CITY OF ALBUQUERQUE

July 19, 2022

**RE: Starbucks – Coors & Brayton
Grading and Drainage Plan
Engineer's Stamp Date: 06/24/22
Hydrology File: J11D017**

**C101**

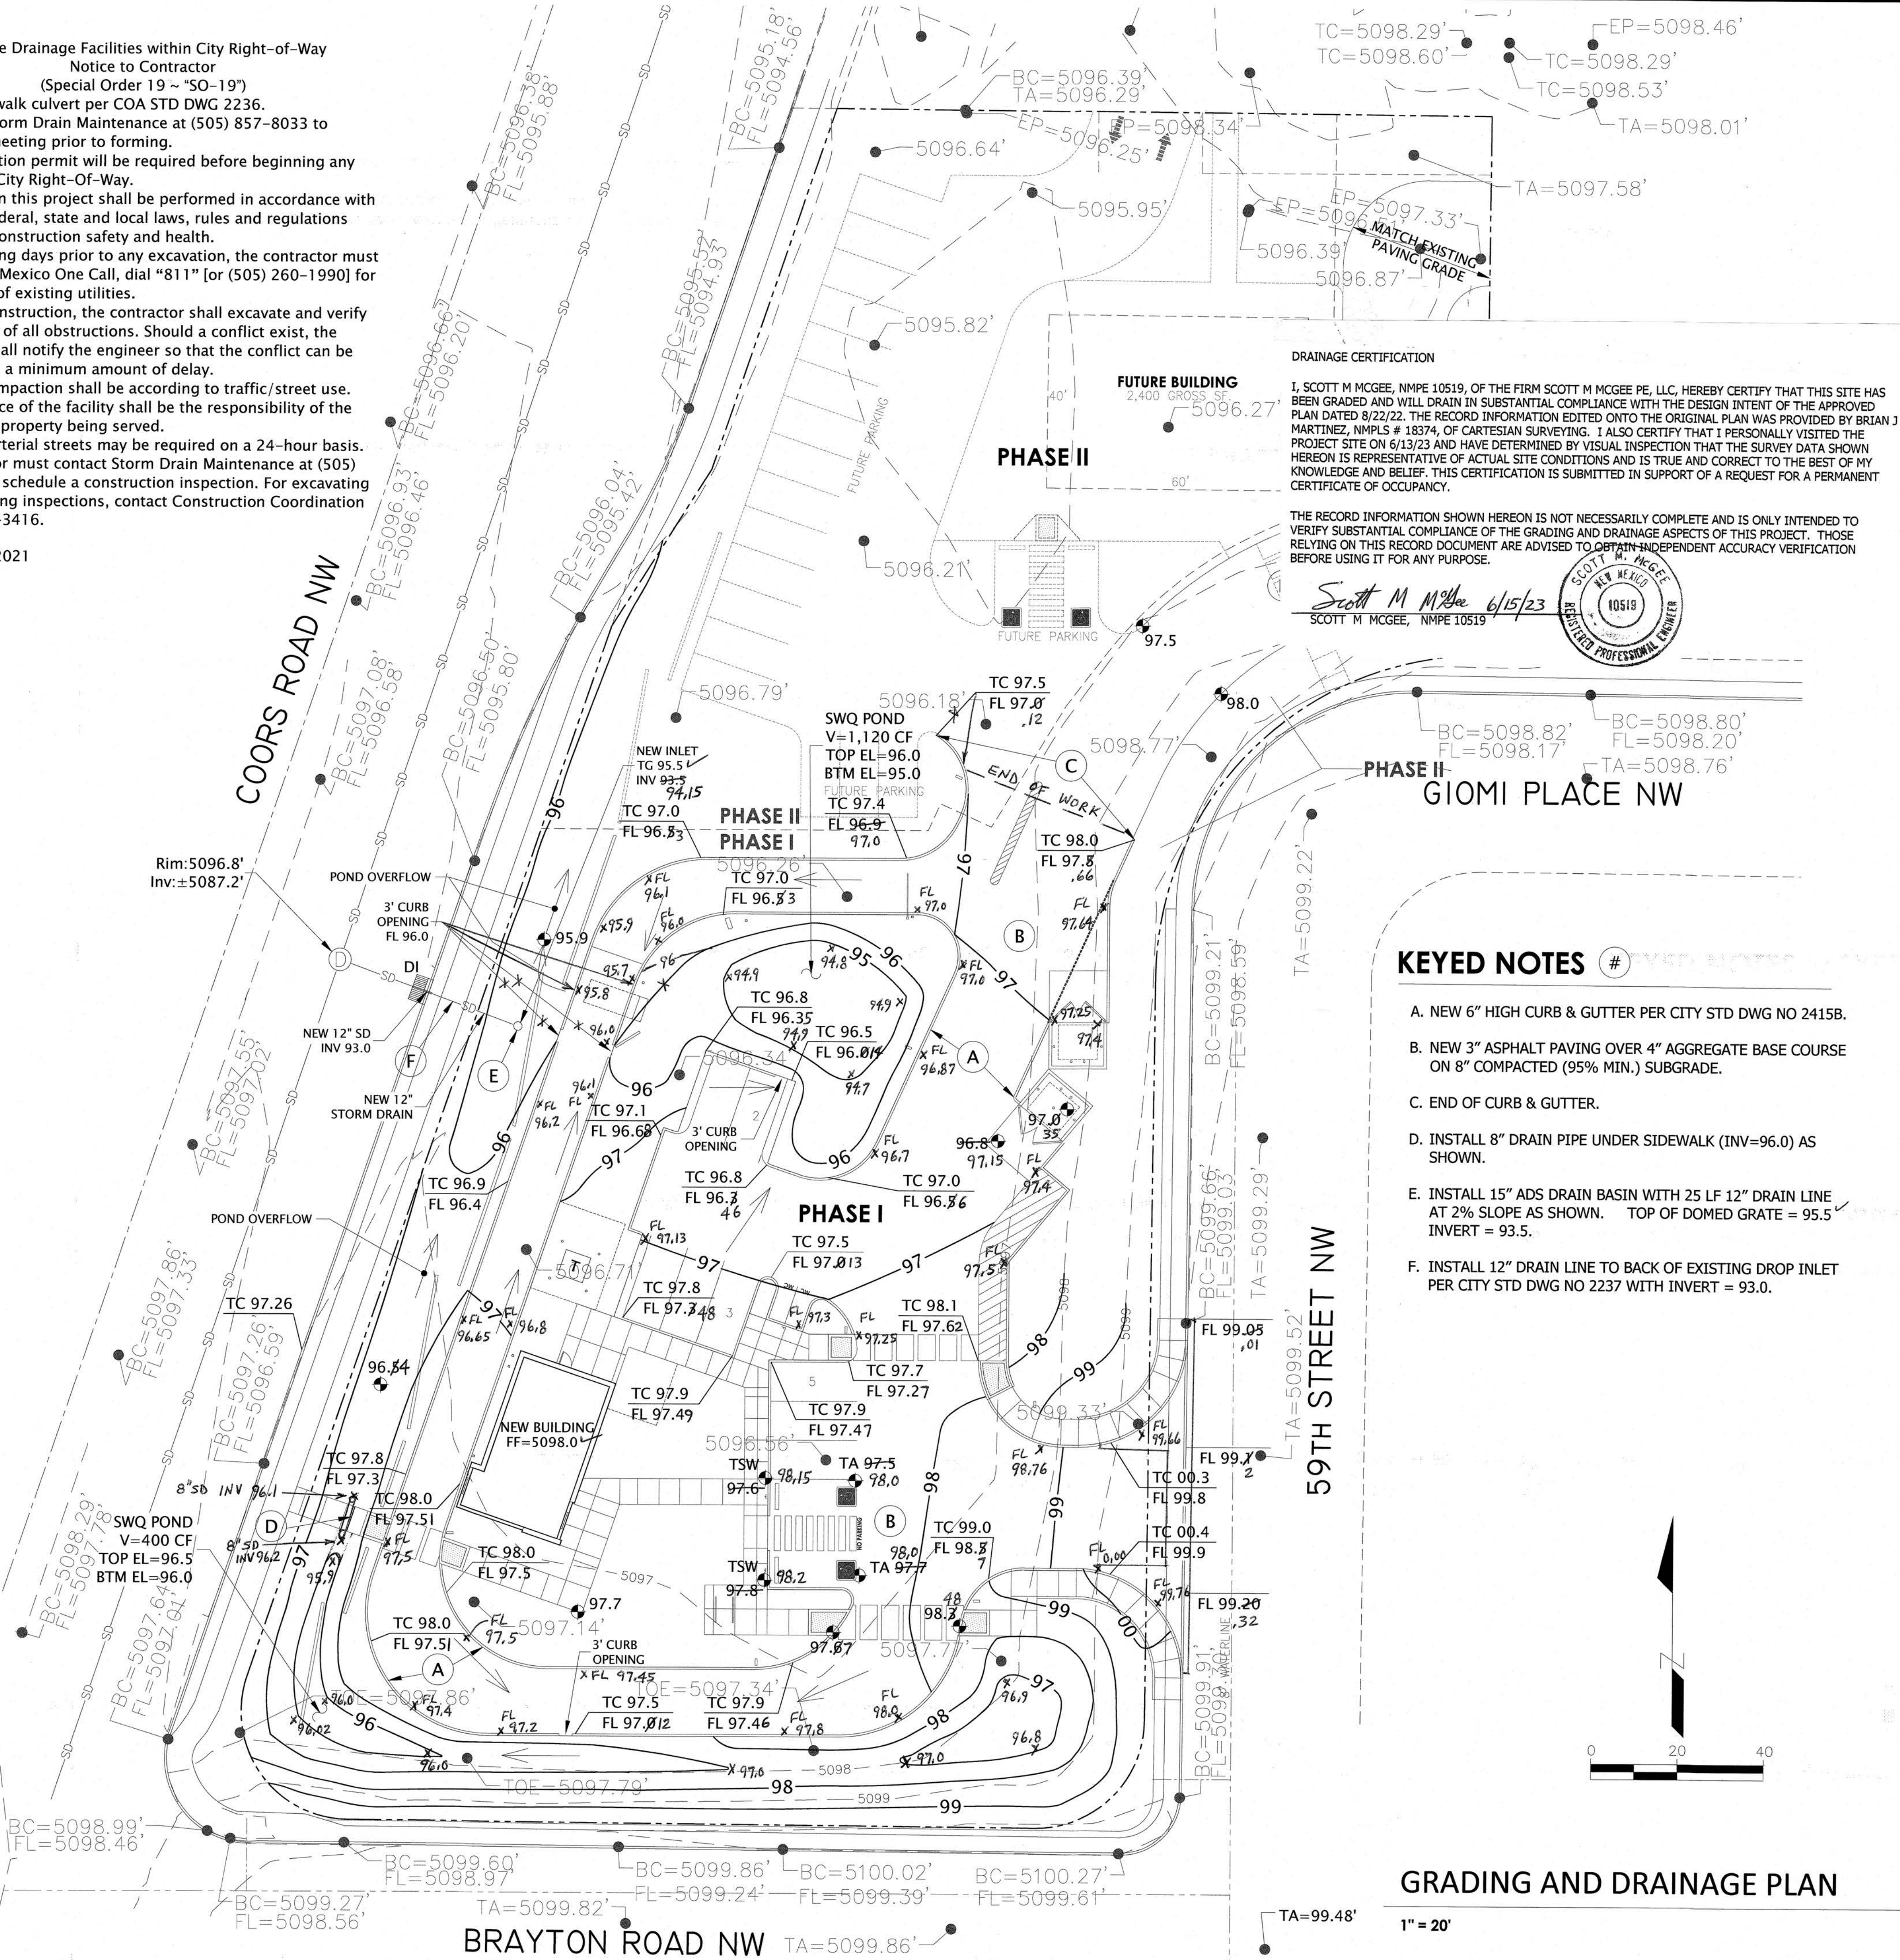
1. It is unclear what is being constructed and what is existing. It is not Hydrology's job to guess and if I can't tell, I know the contractor will not be able to tell as well. In places the line work for the existing is the same line weight as proposed. The only items that stands out are the proposed contour lines. Is the proposed pavement asphalt? At the edge of pavement at places there is a call out of top of curb and at others there is just a spot elevation but the line work is the same at both spots a single line it is not clear where the proposed curbing onsite starts and where it stops. The standard for a curb is a double line. Please clean this up.

2. It appears that there is proposed grading and construction work being done on a tract of land that is not owned by the project Owner. Provide written and signed permission from the adjoining property owner for work on their property. This should be notarized.

3. Please call out the stormwater quality ponds and include the provided SWQV and elevation of the SWQV and the bottom of the pond elevation. There is a pond at the southeast corner that does not have drainage going to it so it is not needed. The pond on the southwest corner discharges to the northeast but there needs a pipe under the connectivity sidewalk for drainage.

4. Where does the entire site drain? The SWQ pond needs a spillway and the site needs to somehow drain to 59th Street or Brayton through a sidewalk culvert or pipe through the curb. Please revise the grading.
